From: [Harmon Rita T.](#)
To: [Scott J. Steffen \(ssteffen@bhinc.com\)](#); [Rick Beltramo \(rbeltramo@gcinm.com\)](#)
Subject: C09D011_PP_Appr : Valle Prado Unit 4 and 5 Stamp Date 1-8-2016
Date: Friday, February 12, 2016 3:41:55 PM

Based upon the information provided in your submittal received 1-09-2016, the above referenced plan is approved for DRB action on the Preliminary Plats.

Prior to Grading Permit, the following comments must be addressed:

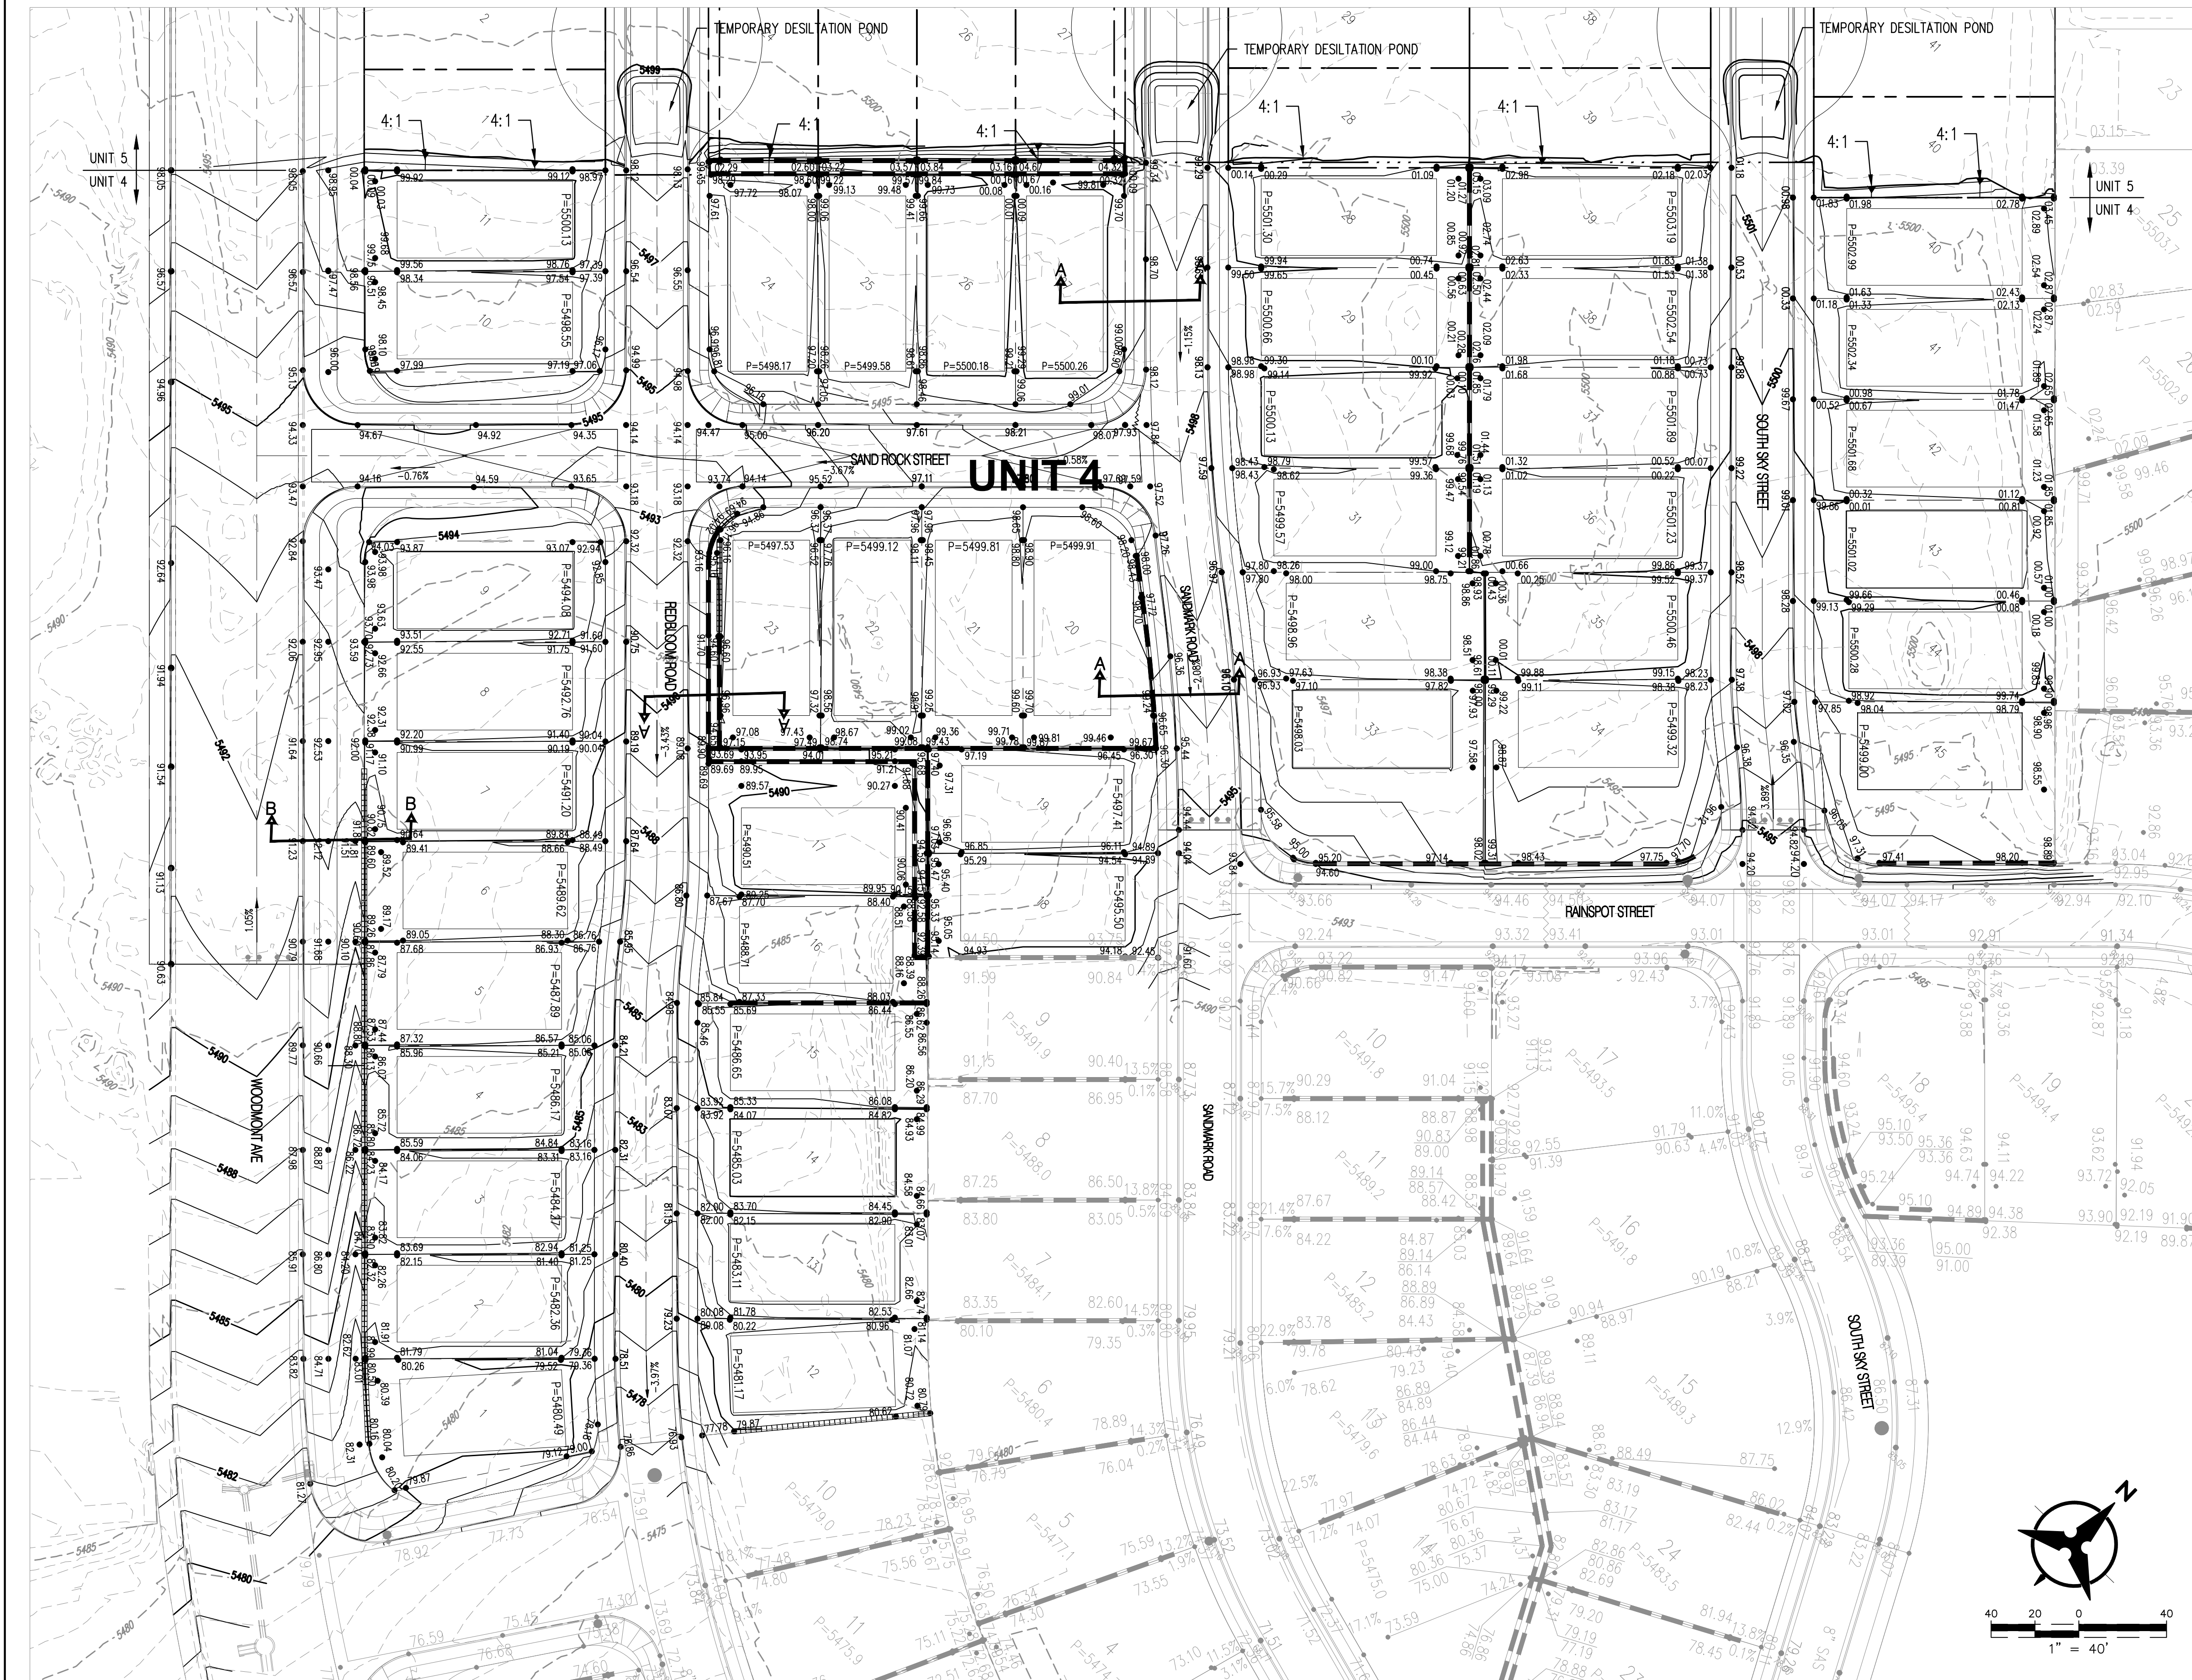
- Interim Grading Plan for Unit 4 is needed showing Temporary Sedimentation Ponds.
- Unit 5 should show a sedimentation pond at the west end of Woodmont Avenue.

POND A5  
 POND BOTTOM=5510  
 100YR-24HR WSE=SWQ ELEV=5514.75  
 POND TOP=5515.00  
 PROVIDED VOLUME 100YR-24HR=1.57 AC-FT  
 REQUIRED 100YR-24HR VOLUME=1.47 AC-FT  
**AS-BUILT VOLUME=1.76 AC-FT**

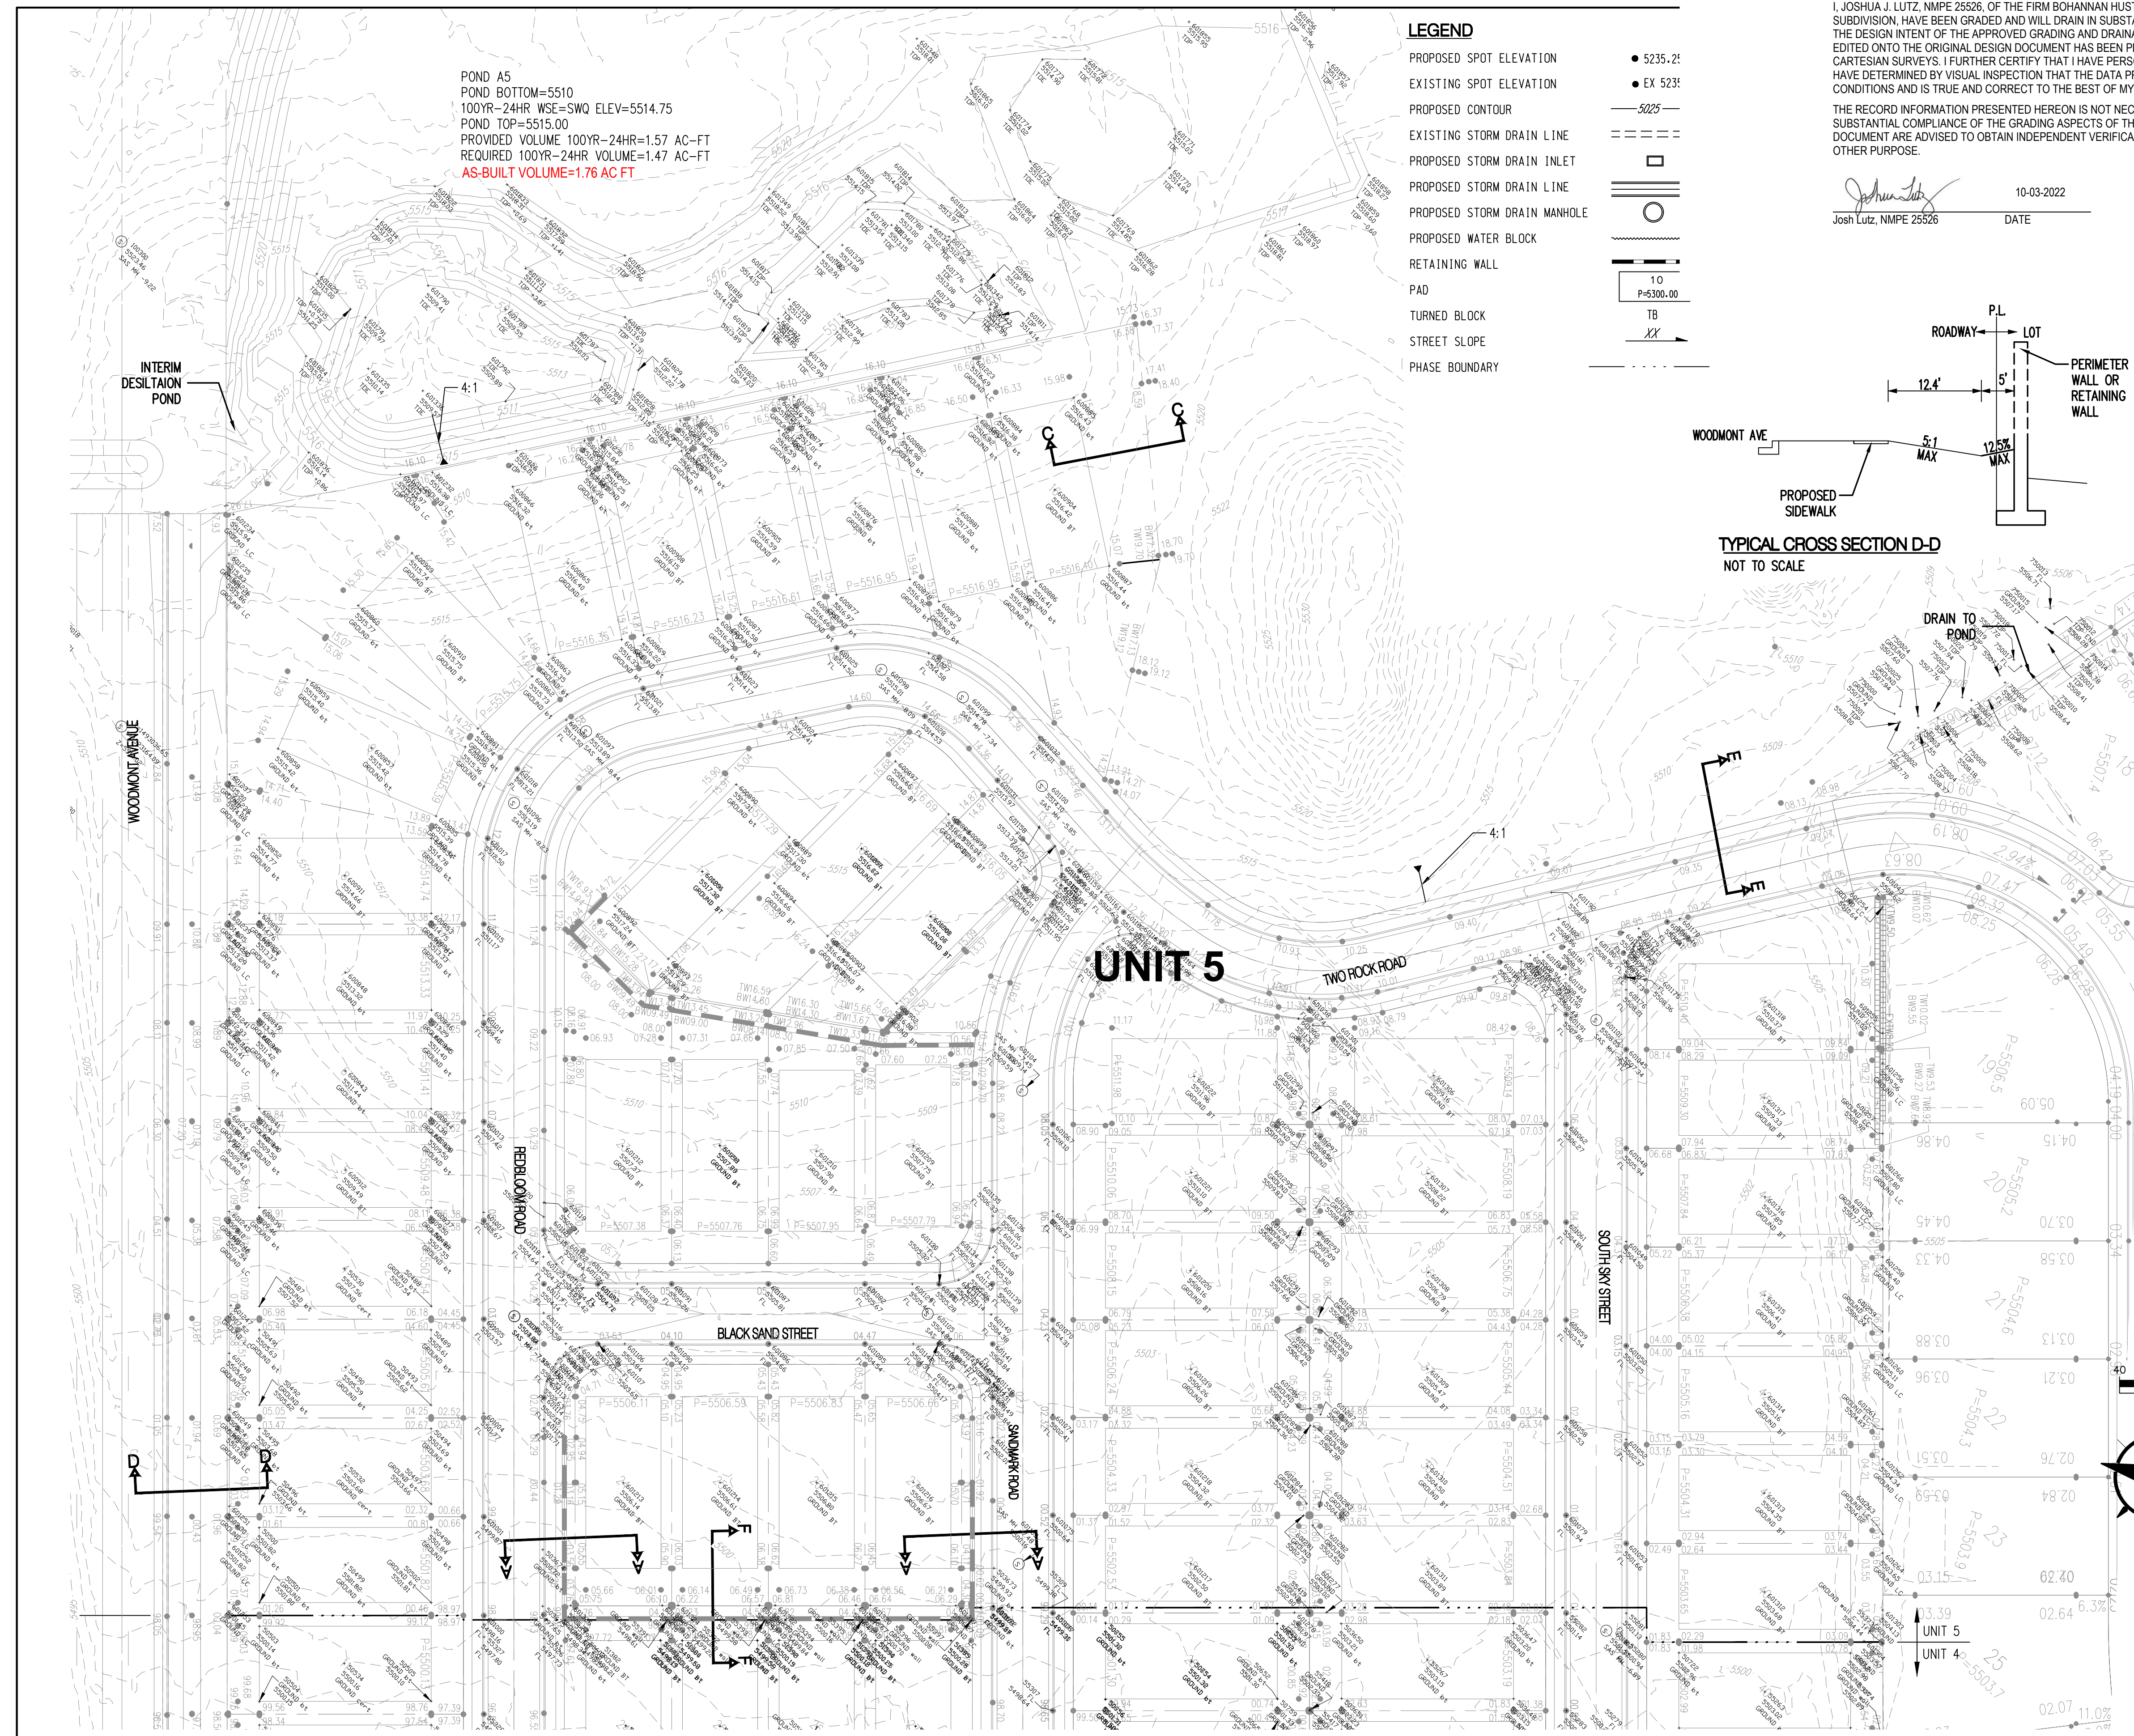
- The Drainage Report shows "Future Pond A5" on western boundary of On Valle Prado Unit 5. When will this Pond be built/graded? Until it is built, how and where will offsite flows be directed? Is a swale needed along the western boundary?

- Was Pond A6 on Valle Prado Unit 3 built? Since this pond collected offsite flows, it seems that Pond A5 should be built for the same reasons.
- It is understood that Valle Prado Unit 3 is to be amended so that grades at the rear of lots 19, 20, and 21 will match those shown on Valle Prado Unit 5. The amended plan should be submitted at the same time or before Valle Prado 5 is resubmitted.
